April 13, 2015

**Subject: Century Tire Plaza – 195 Kennebec Street
Project ID# 2015-027
Review Comments Received April 8, 2015**

PROJECT	CENTURY TIRE PLAZA 195 KENNEBEC STREET, PORTLAND, ME
SHEET TITLE	EROSION AND SEDIMENT CONTROL PLAN
CLIENT	NORTHLAND ENTERPRISES, LLC

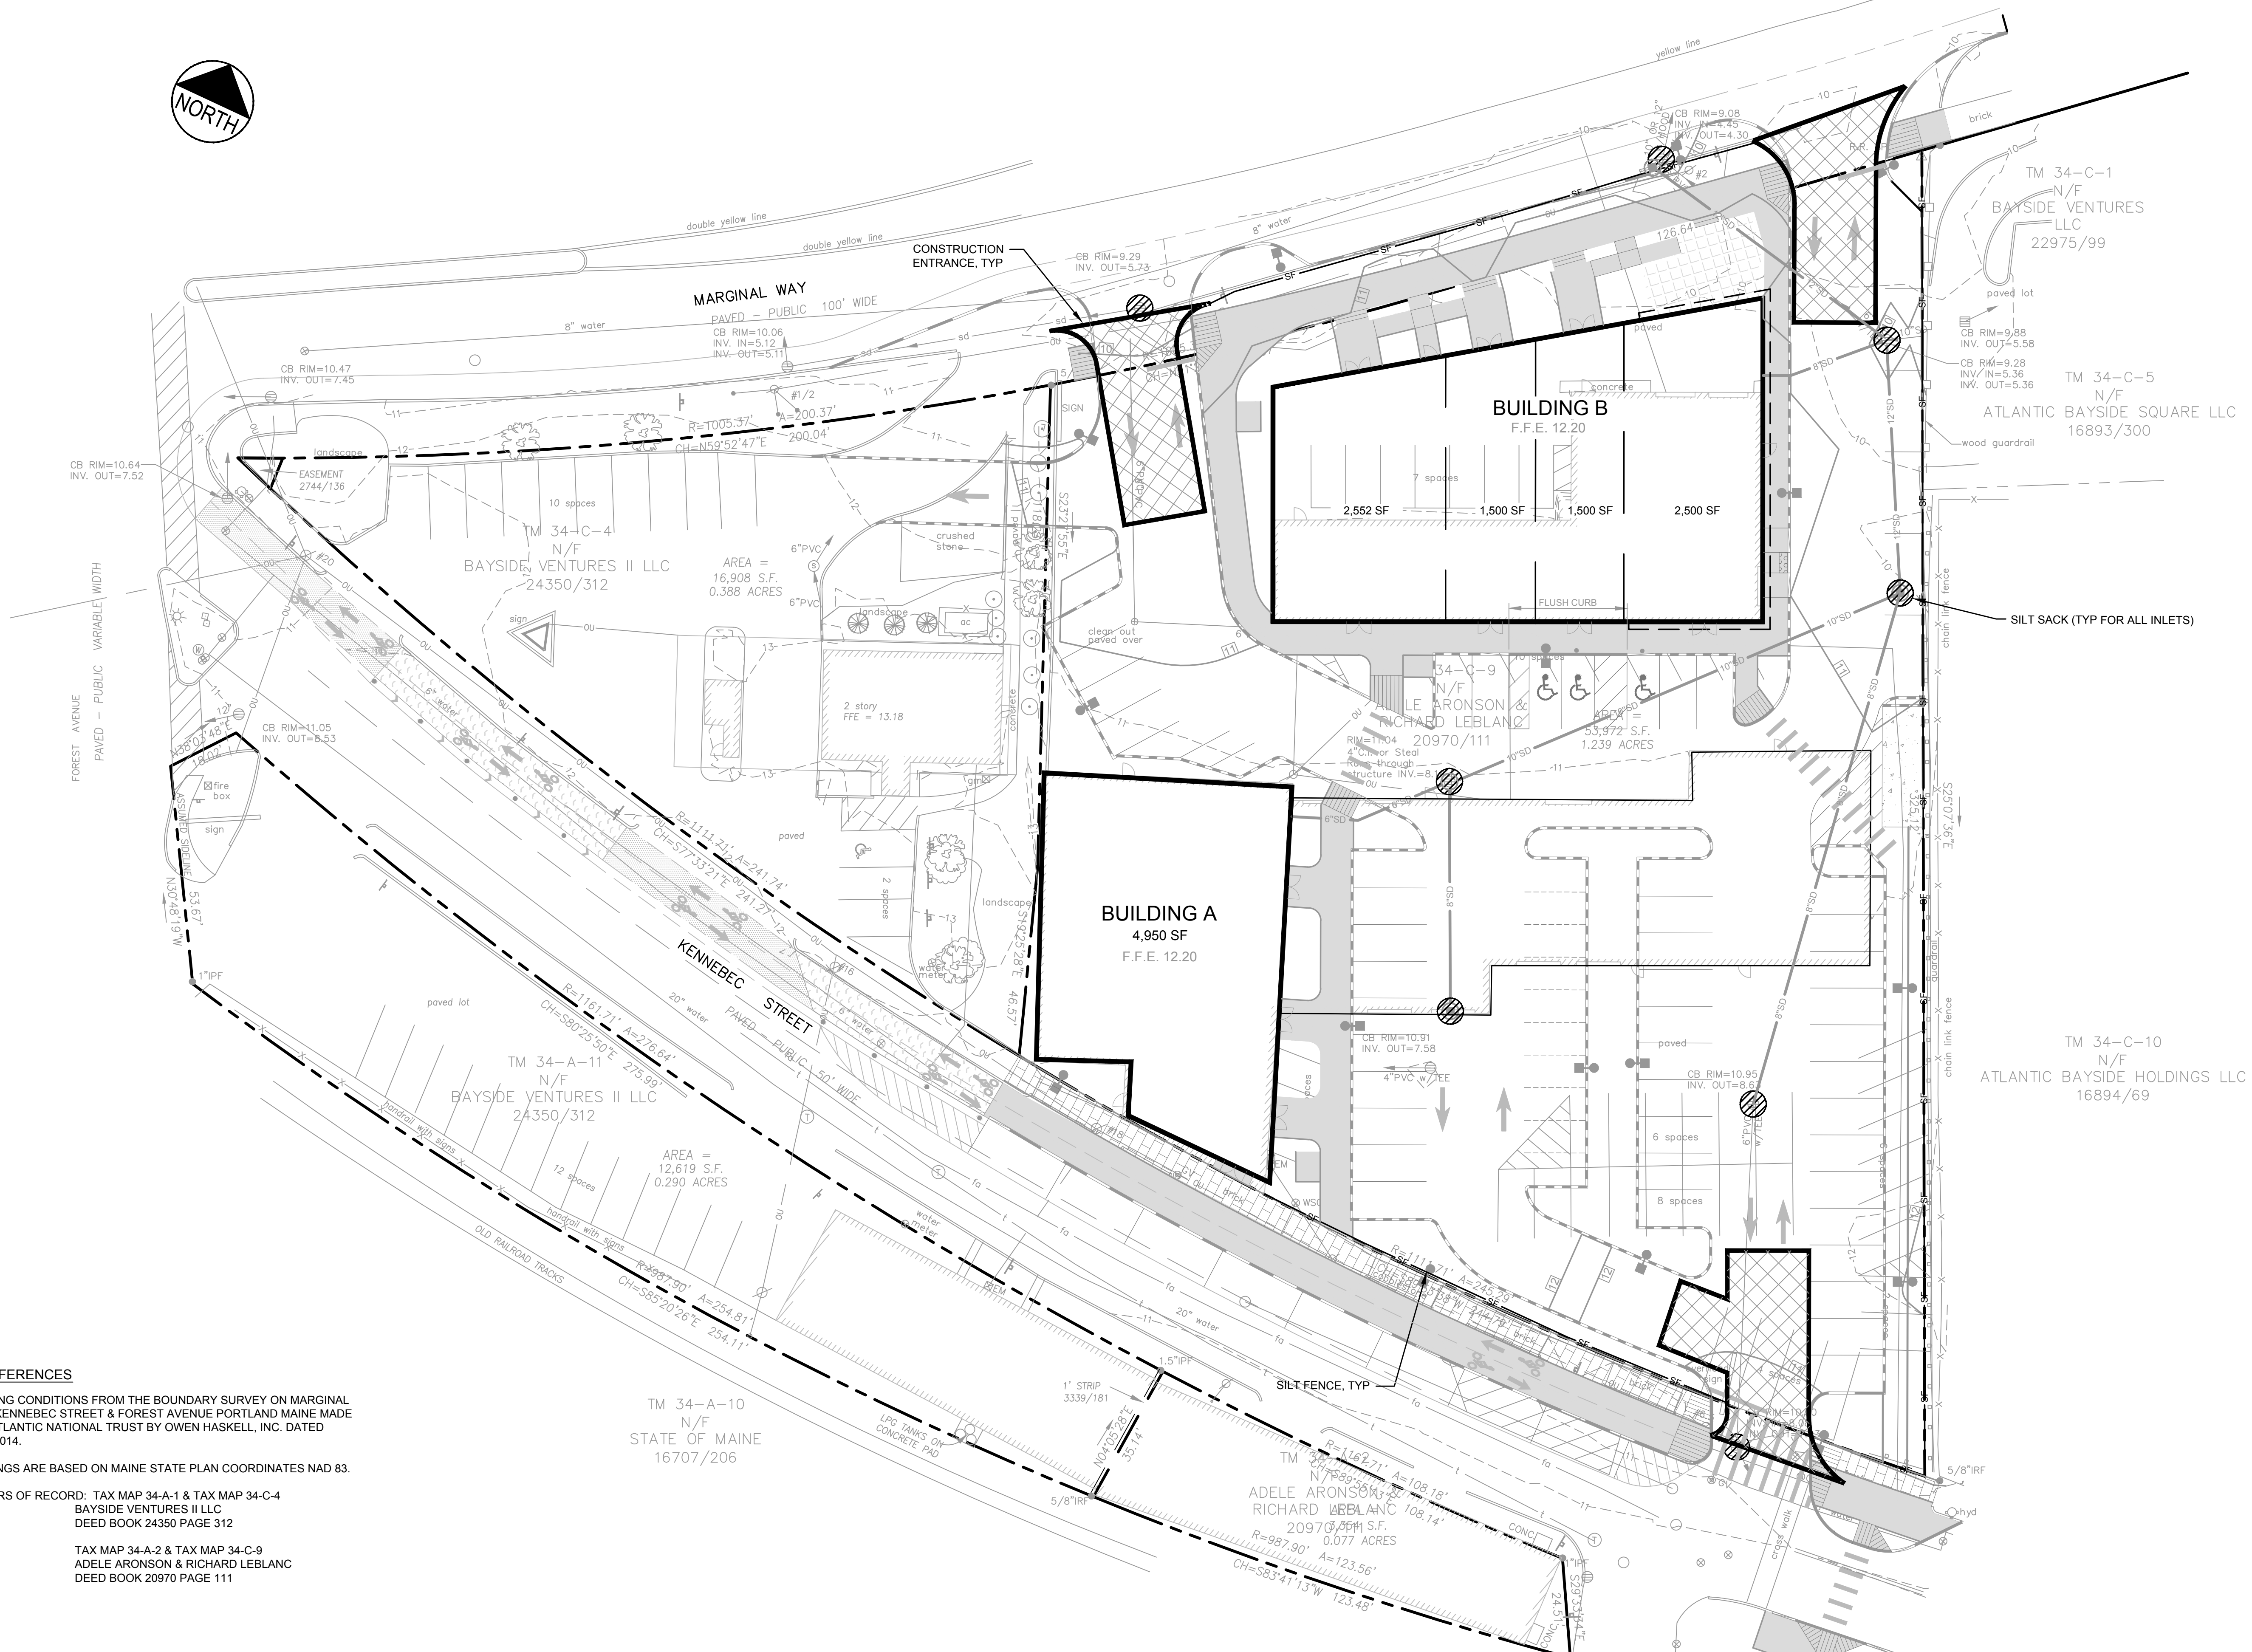
The revised Sheet C-5.0 Erosion and Sediment Control Plan no longer includes the erosion and sediment control practices that were identified on the originally submitted plan. This plan should be revised to reflect the original submittal.

The erosion and sediment control measures were shown on Plan Sheet 5.0, revised 04/01/15. This sheet has been reissued, dated 04/10/15 to reflect the layout changes requested in other comments.

Date: 5/18/15
 Design: PBB
 Drawn: DEPT.
 Checked: PBB
 Date: JAN 2015
 Scale: 1"=20'
 Project No.:
 Drawing No.: L1.1
 Rev.: D

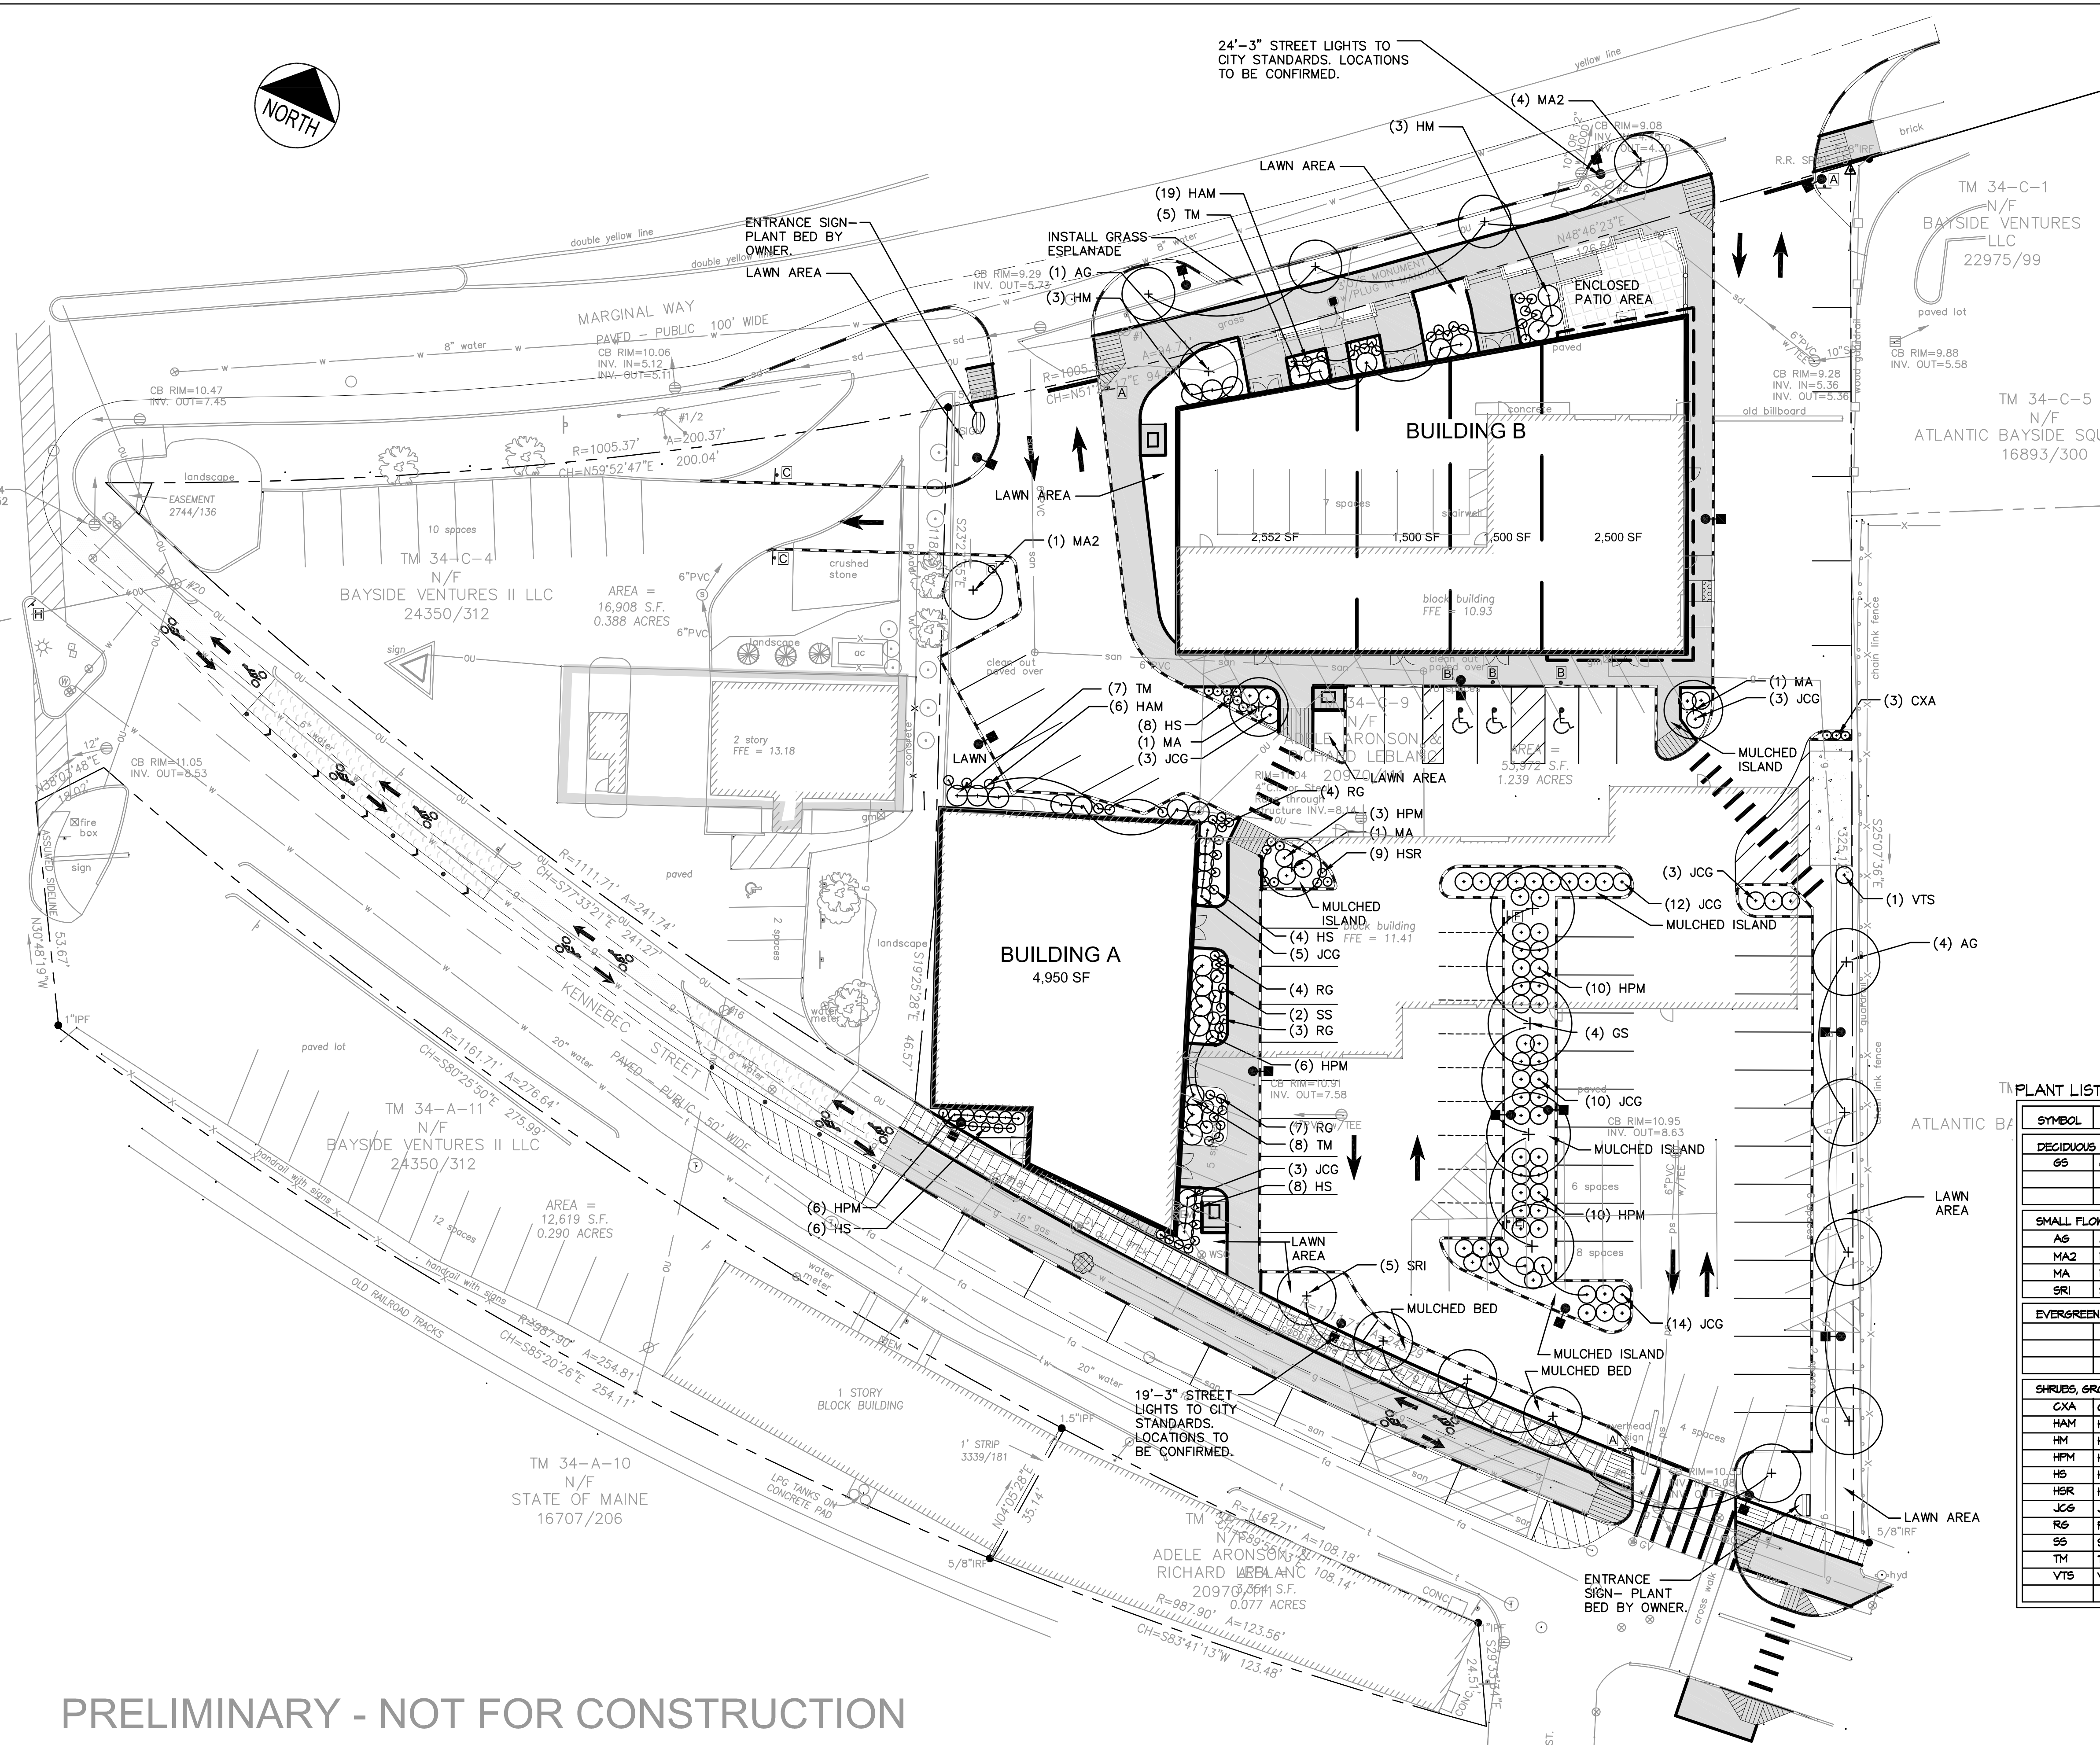
Likewise, per our development review meeting this morning, DPS has advised that note #18 on the landscape plan should be struck. DPS has also asked for an electrical plan for the streetlights. Apparently there are some considerations about tying in with the network east of here.

There are some concerns about continuing to plan to store snow along the pedestrian pathway along the eastern edge of the site. How will this work with curbing? It seems like all snow may need to be removed?

Note 18 has been removed from the revised Landscape Plan. An electrical plan for the street lighting will be provided under separate cover.

The snow storage area will be eliminated at the eastern edge of the site. Snow will be eliminated at the eastern edge of the site. Snow will need to be removed.
